Application No: M/12/25/HH

Site Address: 1 Harefield Road Middleton-on-Sea PO22 6EB

Description of works: Two storey side extension, installation of front and rear dormers and alterations to fenestration, following the demolition of existing side garage and removal of existing side dormer.

Thank you for your internet representation made on 7th March 2025 which has been recorded as an objection with the comments as follows:

Proposed Side and First Floor Extension Site Location Planning
Date August 2024
Scale 1:200 1:1250

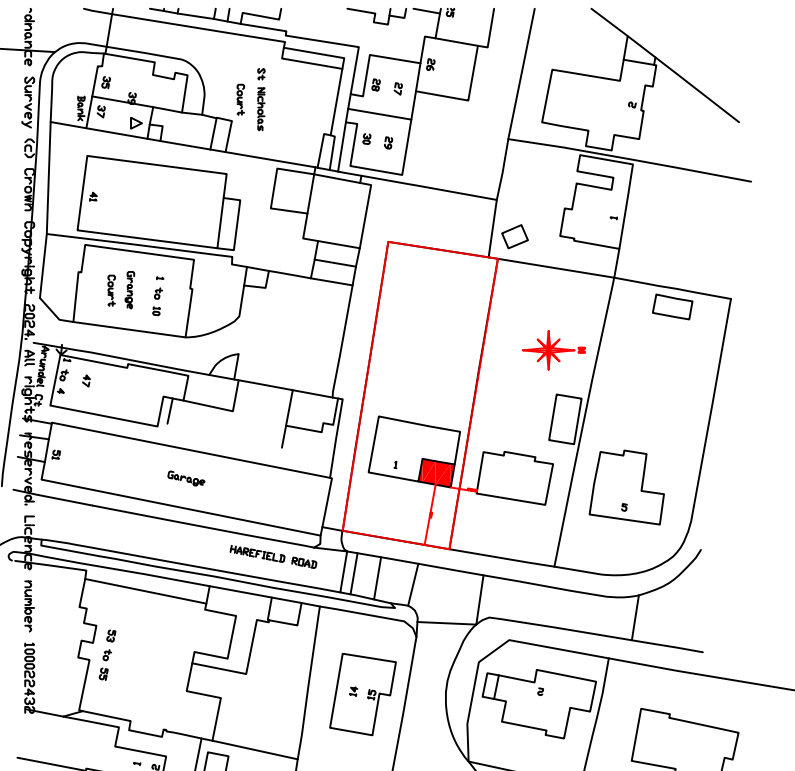
1) The plan submitted with the application again shows the original boundaries of 1 Harefield Road and agrees with the layout filed with the land registry. However the size of the plot has been substantially reduced by the expansion of the yard area to the south and west (Land registry Title number WSX90392). As such the property now stands on a much smaller plot than indicated in the plan. The form and scale of the proposed extension is once again an over-development for a plot of this size.
